## Request for Clarification of Information

Address: 1576 Forest Avenue

Permit #: 2016-02870

Date: 2/1/2017

Macleod Structural Engineers, P.A. 404 Main Street, Gorham, Maine 04038 207.239.0980	
Moroni's Market Renovation 1576 Forest Ave. Portland, Maine	
DATE: 10/25/16 SCALE: as noted	DRAWN BY: BMM PROJ. NO: 2016-070
TITLE: FIRE BLOCKING/PENETRATIONS DRAWING NUMBER: LS-2

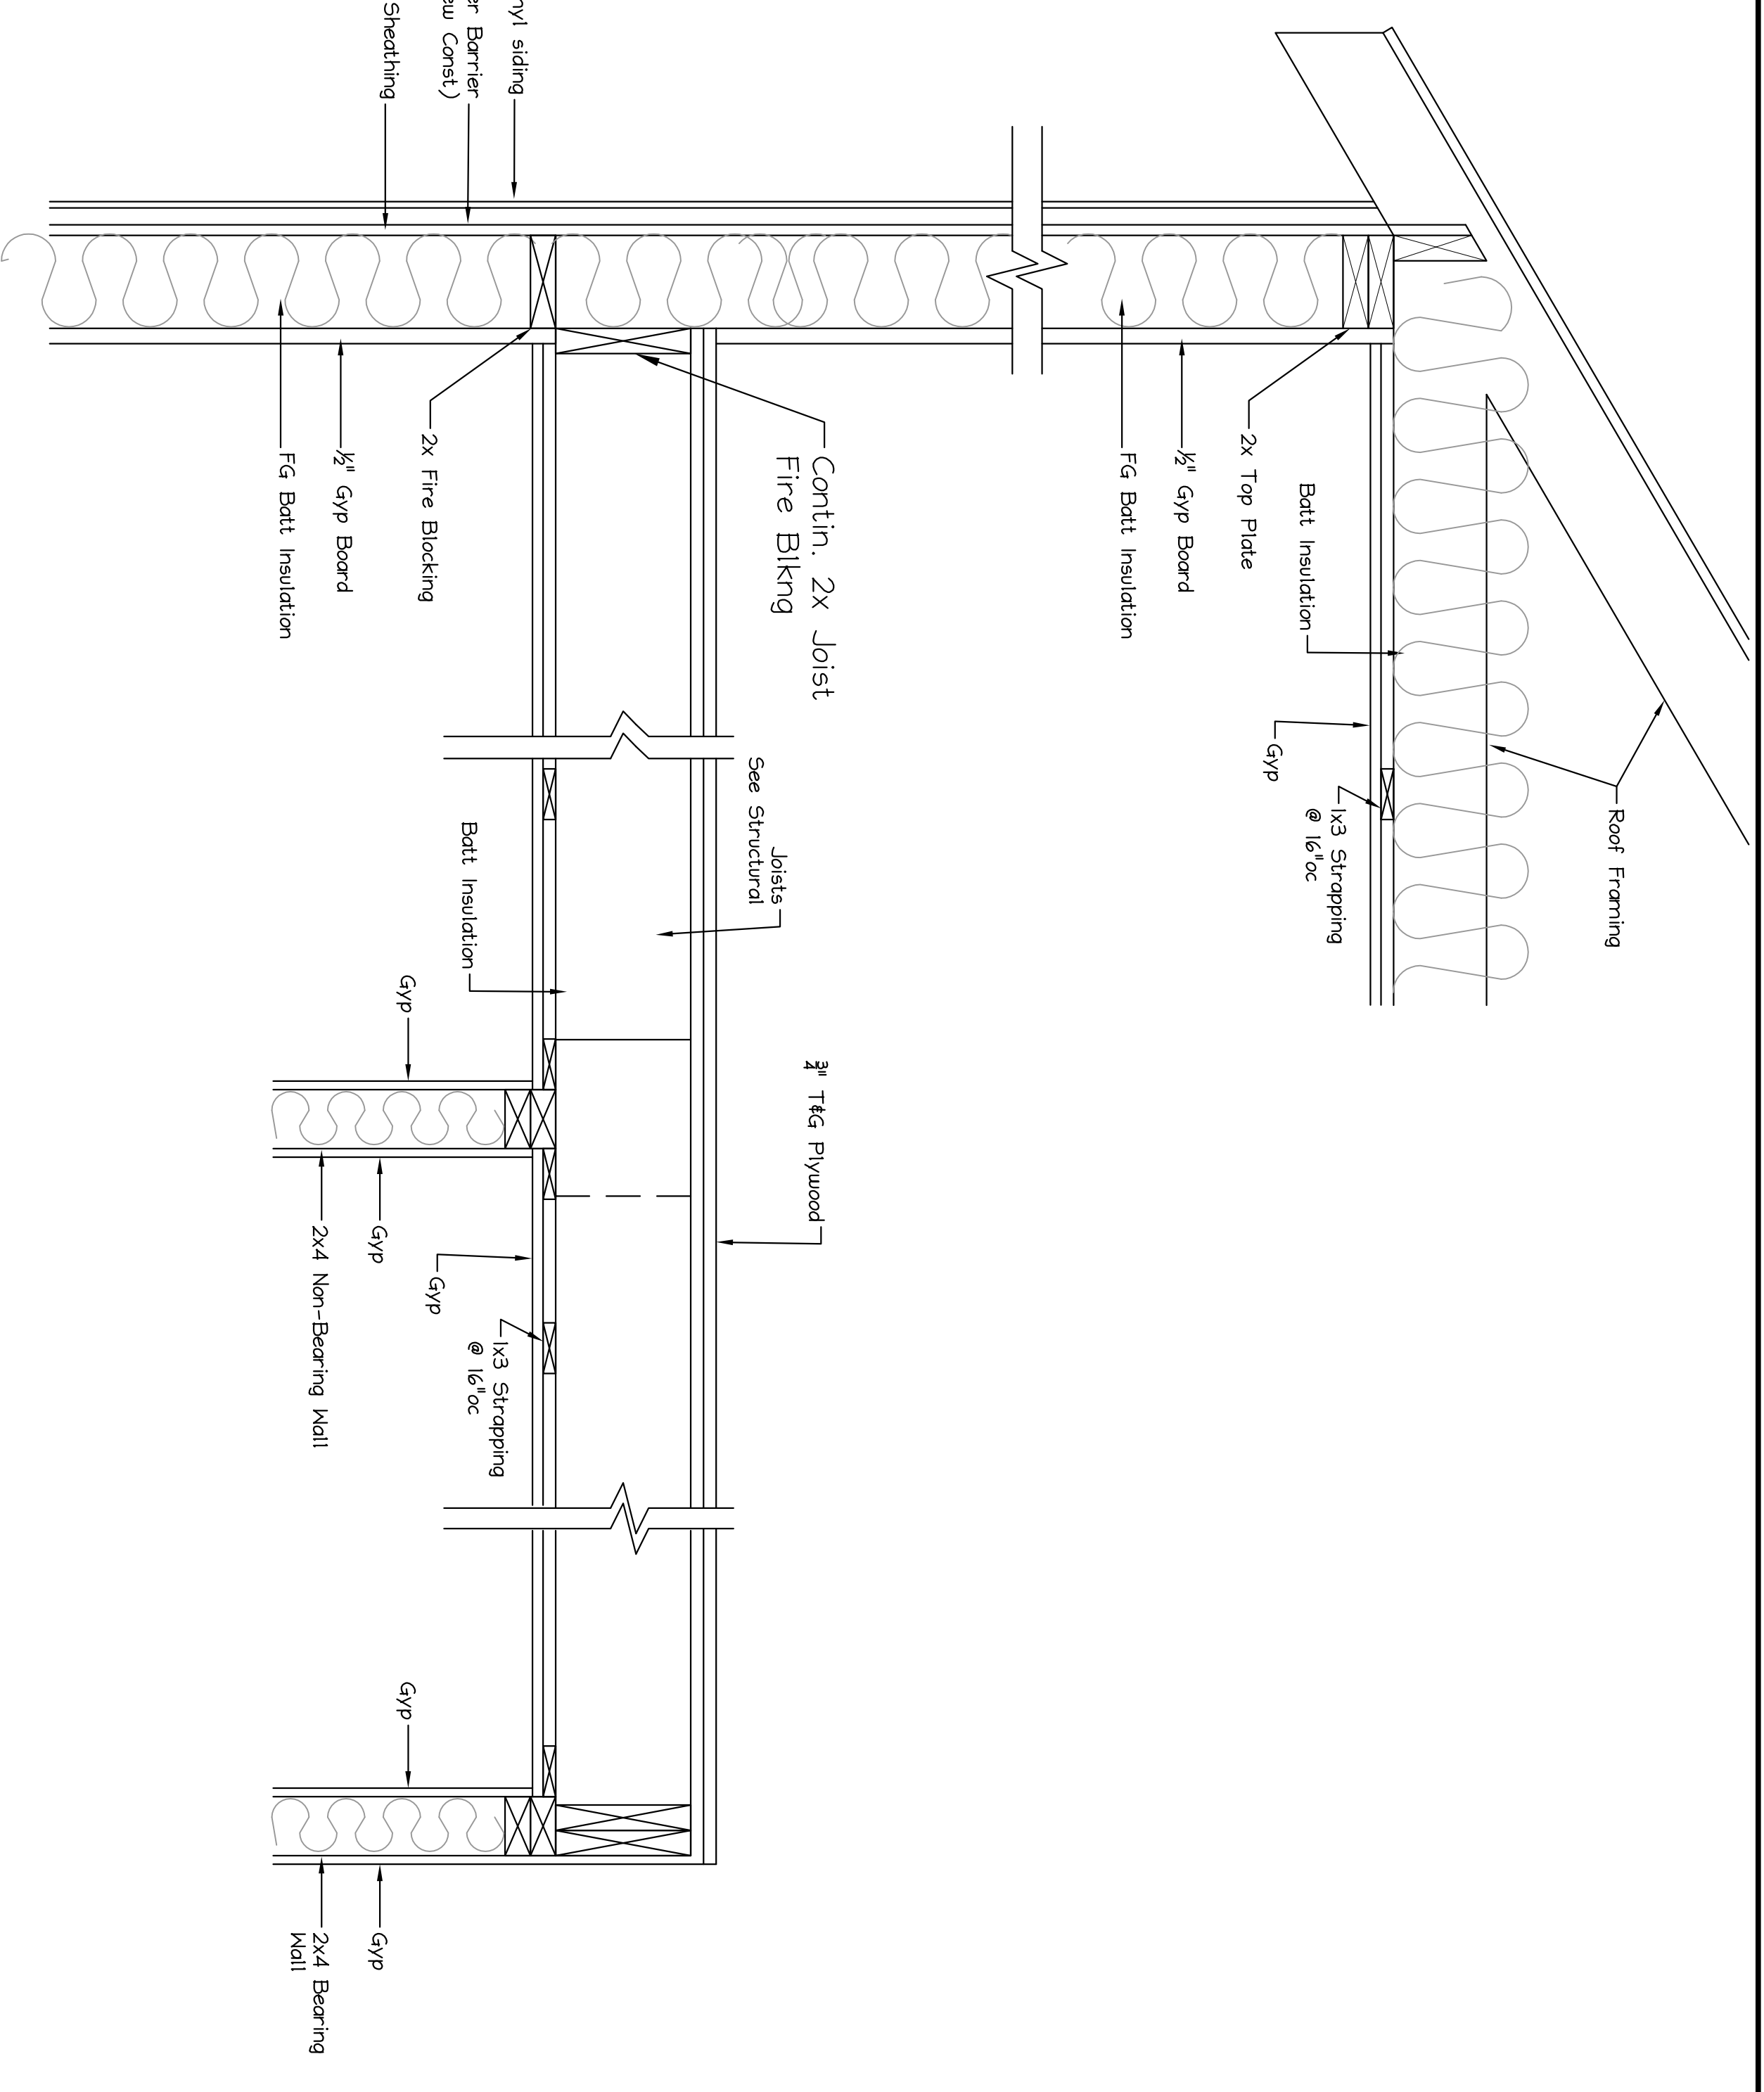
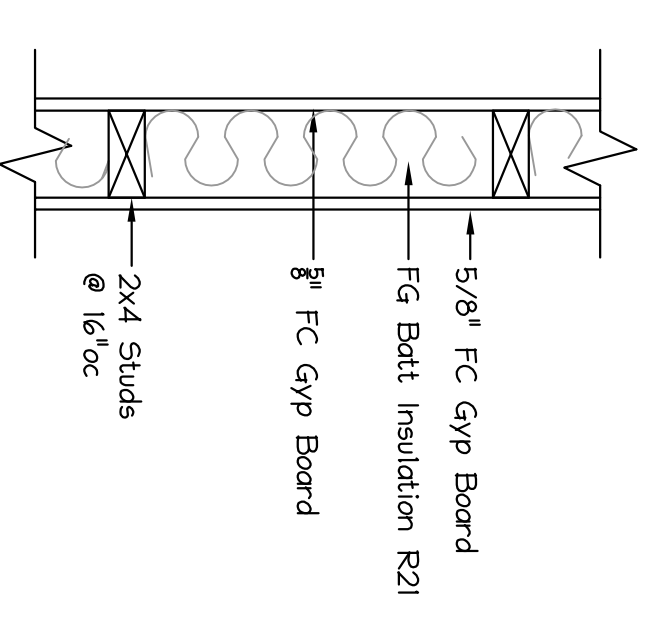
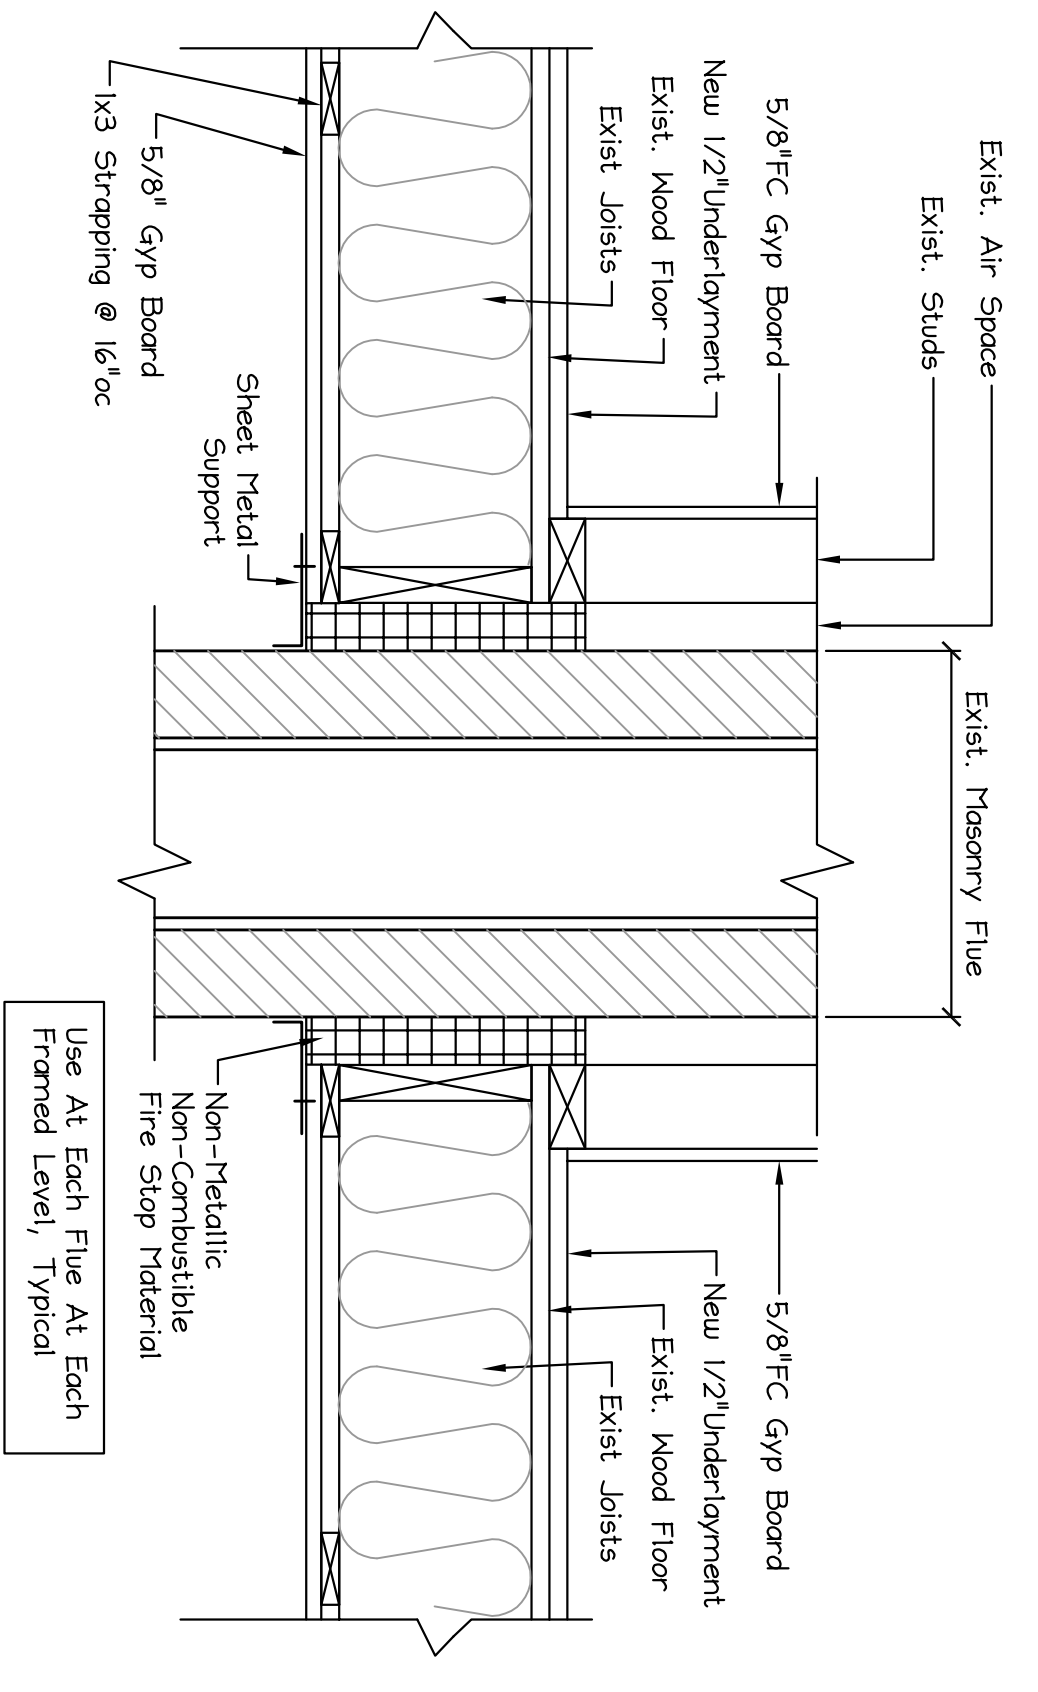
1. Provide window and door schedule for all new doors and windows. Show sizes, style of window or door, which windows are egress windows, if the windows are tempered, any other special concerns.
2. Show proof (calculations) for frontage and height compliance per analysis on cover sheet.
3. Provide Deck details for structure and connection to the building as the deck on the 3<sup>rd</sup> floor is being altered
4. Provide new basement plan and use of basement (nothing more than storage allowed)
5. Clarify if the restroom in the basement is to remain
6. Because you have specified that you are using data from multiple code books, when you call out sections in you code analysis, specify which code the section is from
7. Sections call out UL #501 details call out UL #301

1. We have revised the plans to include door and window information as requested
2. The frontage and height compliance information is provided on the cover sheet in the code analysis under the section "Building Use Summary" . No modifications for frontage and sprinkler were calculated as the building meets requirements without these additions.
3. The decks are NOT altered as part of these plans. The decks are to remain as is.
4. New basement plan has been added.
5. The bathroom in the basement is to remain.
6. The notes have been revised to include code information where necessary.
7. The label on dwg. LS-2 has been revised to call out U#501 .
